to:	Smart Living Properties - Mr. Rakan Abushaar Rakan@smartlivingproperties.ca
cc:	Smart Living Properties - Mr. Brian Tettman Brian@smartlivingproperties.ca
re:	Geotechnical Review of Revised and Approved Plans 84 to 96 Hinton Avenue - Ottawa
date:	May 8, 2020
file:	PM7842-MEMO.06
from:	Andrew J. Tovell

As requested, by Smart Living Properties, Paterson Group Inc. (Paterson) has conducted a geotechnical review of current City Approved revisions of plans relating to an application to revise the Site Plan Control for the 84 to 96 Hinton Avenue development.

Paterson are the geotechnical engineers of record for the proposed development. Our Supplemental Geotechnical Assessment, File PM7842-3R.REP, dated August 15, 2017, is the geotechnical report for the proposed development. The purpose of this memo is to confirm that the findings and recommendations within that report are still valid for the current City Approved revisions of plans that are noted below.

170453 - GR1

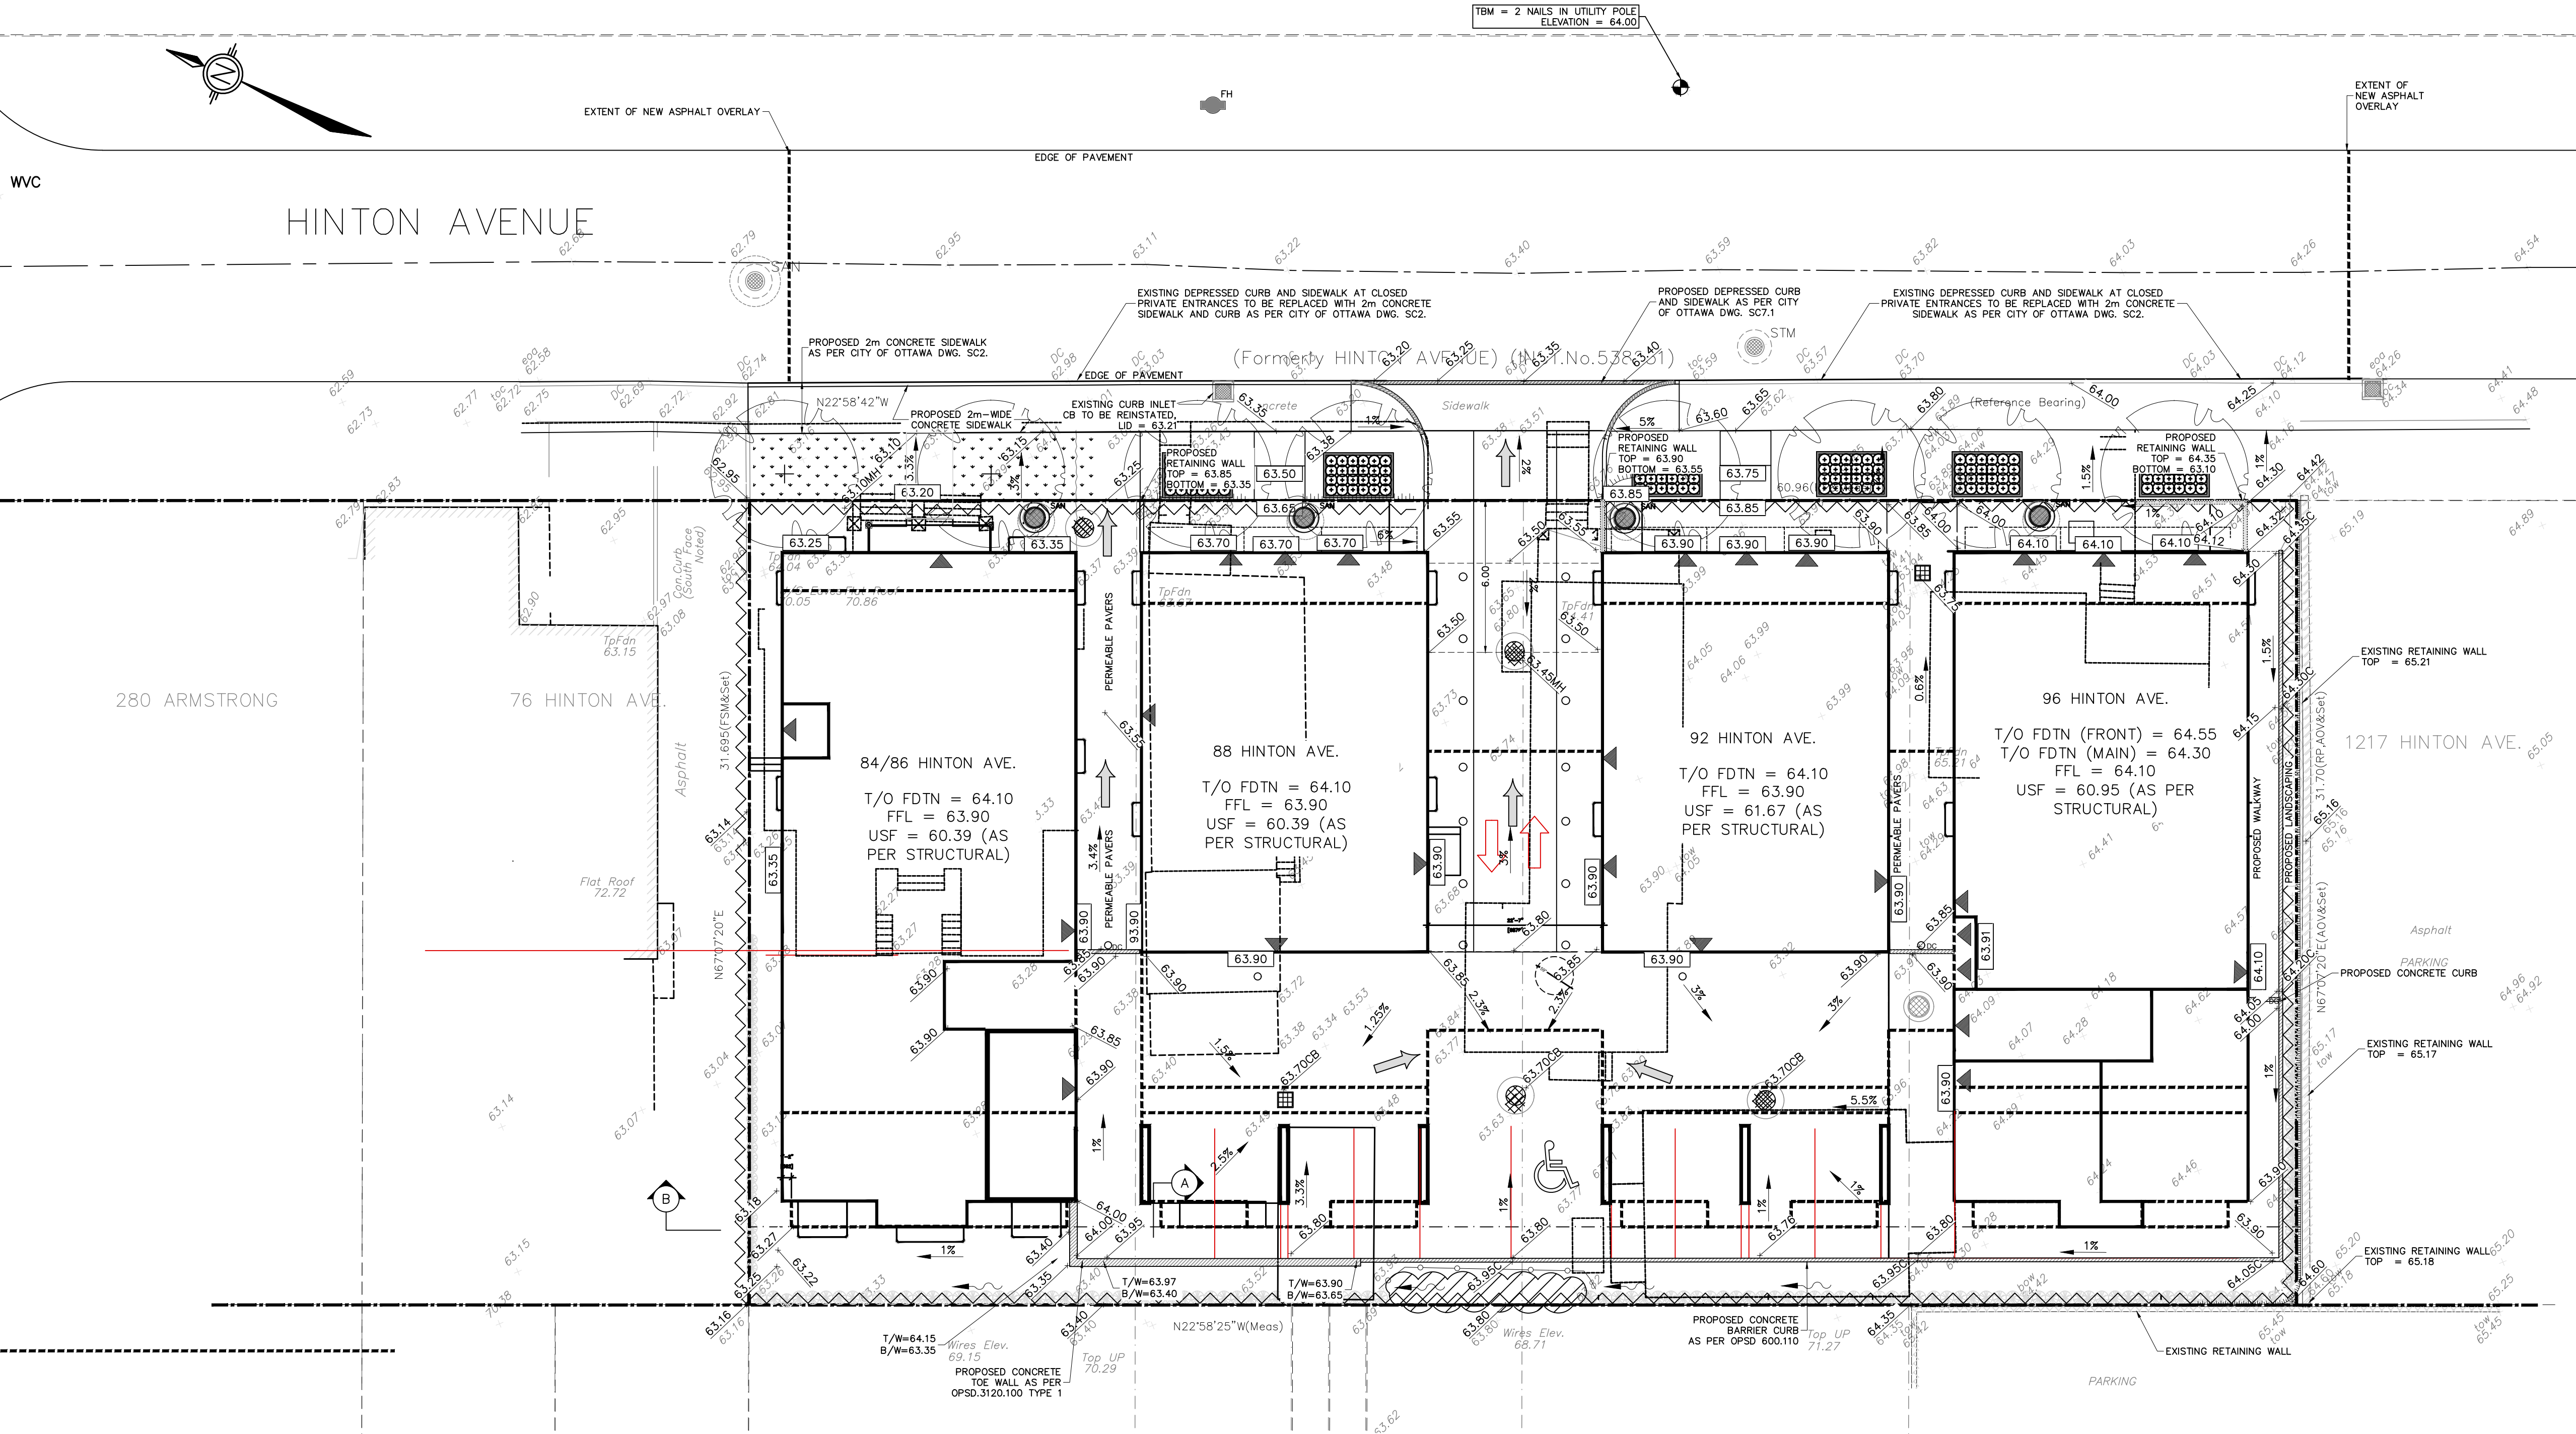
The underside of footing elevations shown on the Site Grading and Erosion Control Plan, Drawing No. 170453-GR1 indicate that the bearing medium for the footings for all the buildings will be the dense to very dense glacial till stratum, as identified in the geotechnical report. As one supplement to our previous recommendations, the glacial till stratum and underlying bedrock are materials that are not susceptible to volume change related to trees and therefore the buildings do not require large separation distances from trees. The locations of the trees shown on the Landscape Plan and Tree Conservation Report, Drawing No. L.1, are acceptable from a geotechnical perspective.
